15 May 2018

File No: 2018/258208
Our Ref: R/2018/5
Your Ref: SSD 85444

Glebe Island Aggregate Handling and Concrete Batching Facility – SSD 8544

GLEBE ISLAND 1 - Proposed Hanson Aggregate Facility & Concrete Batching Plant

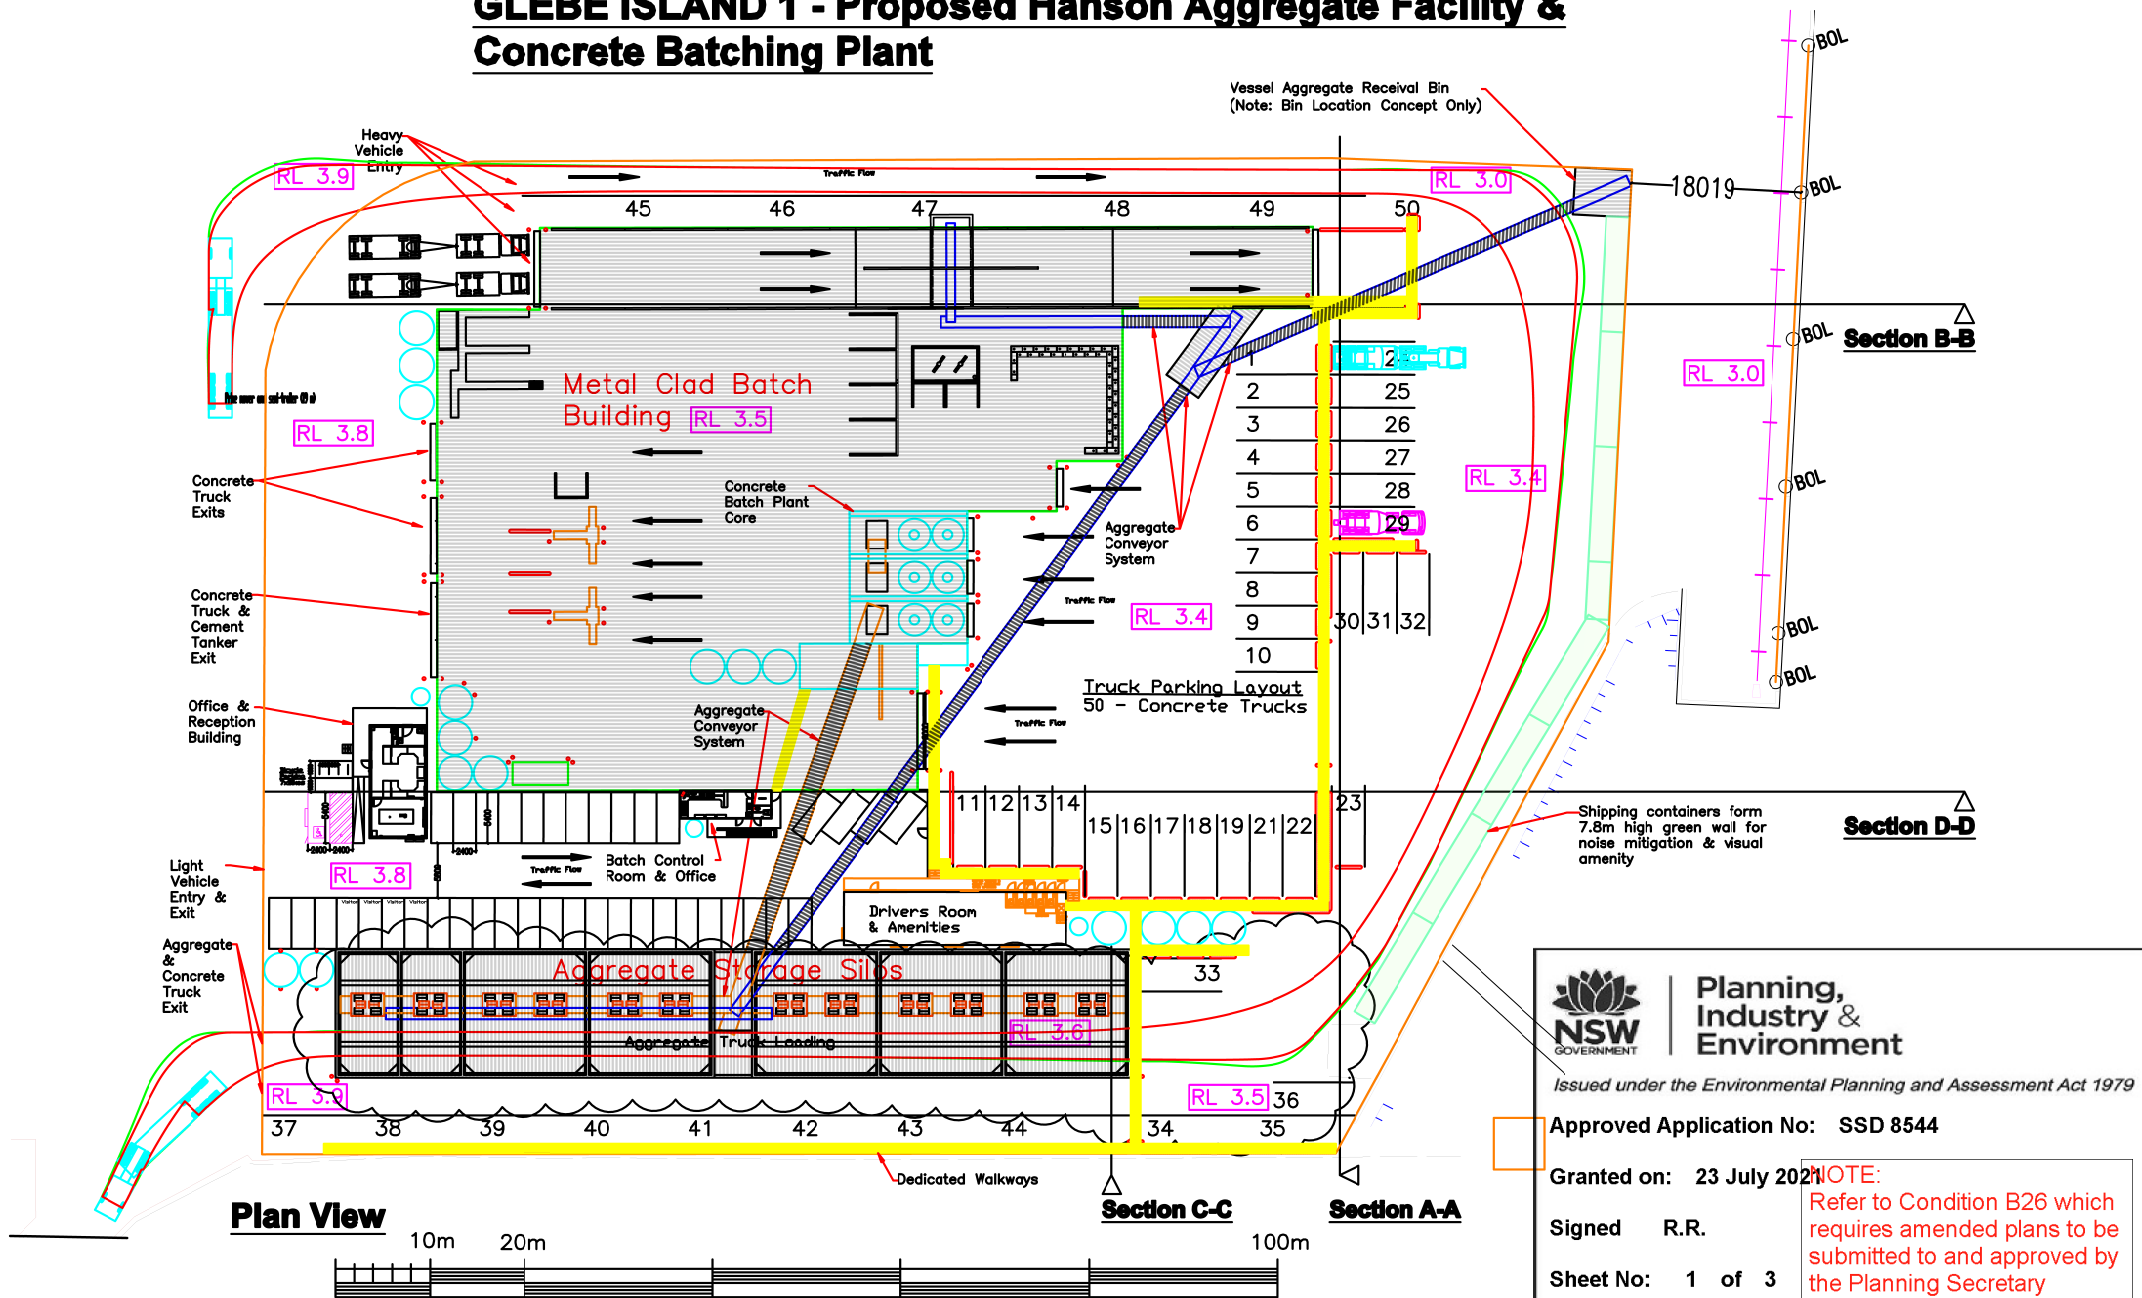
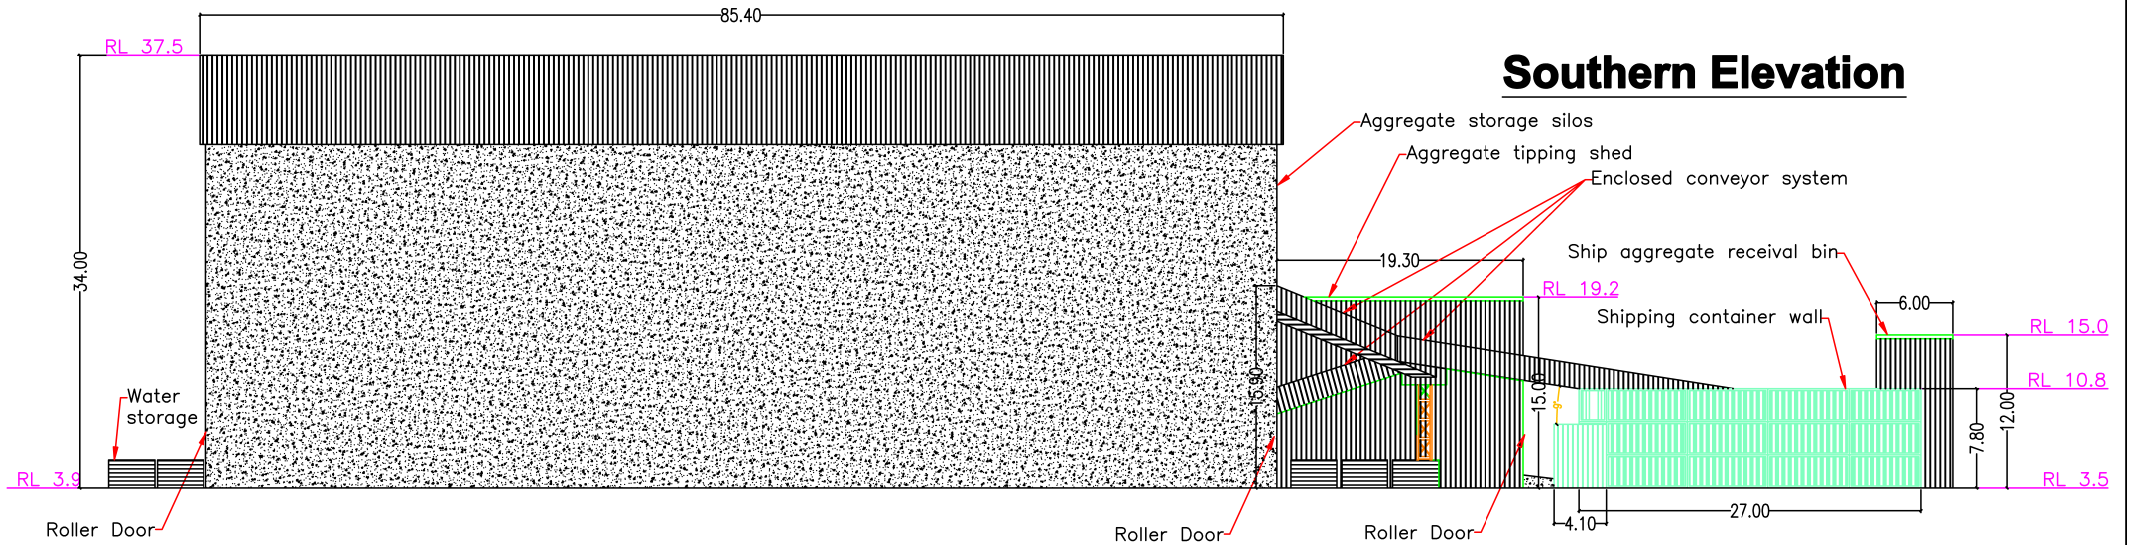
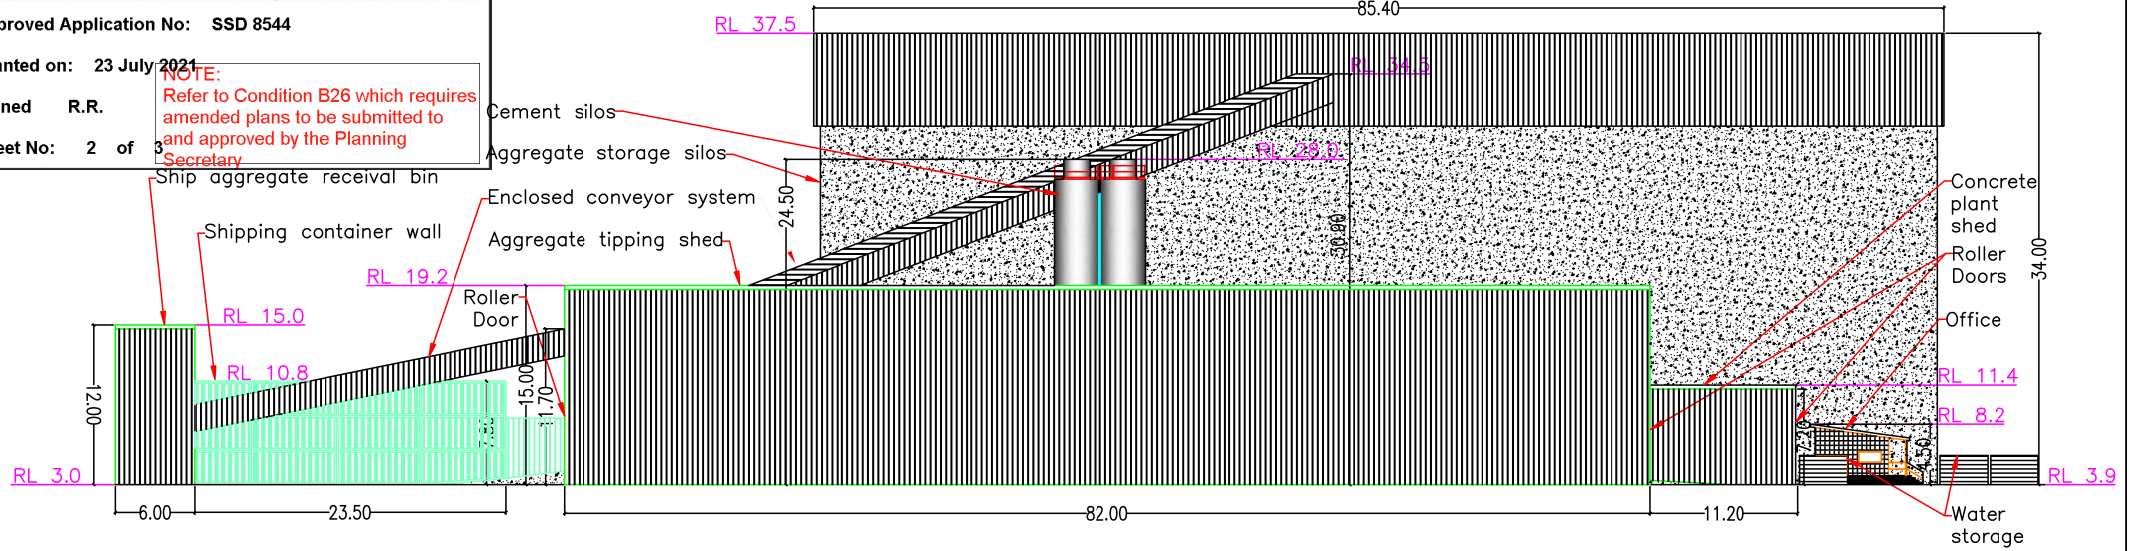
The three 'Technical Drawings' submitted are limited in details and not of the standard expected with a development application. For example, there is no height nominated for the silos and other tall structures, there are no materials and finishes nominated, there is no north point etc.

As noted earlier, the submitted drawings are lacking in detail. Nevertheless, landscaping and public art strategies should be required to mitigate the visual impacts of the proposal. Public art should not include advertisements.
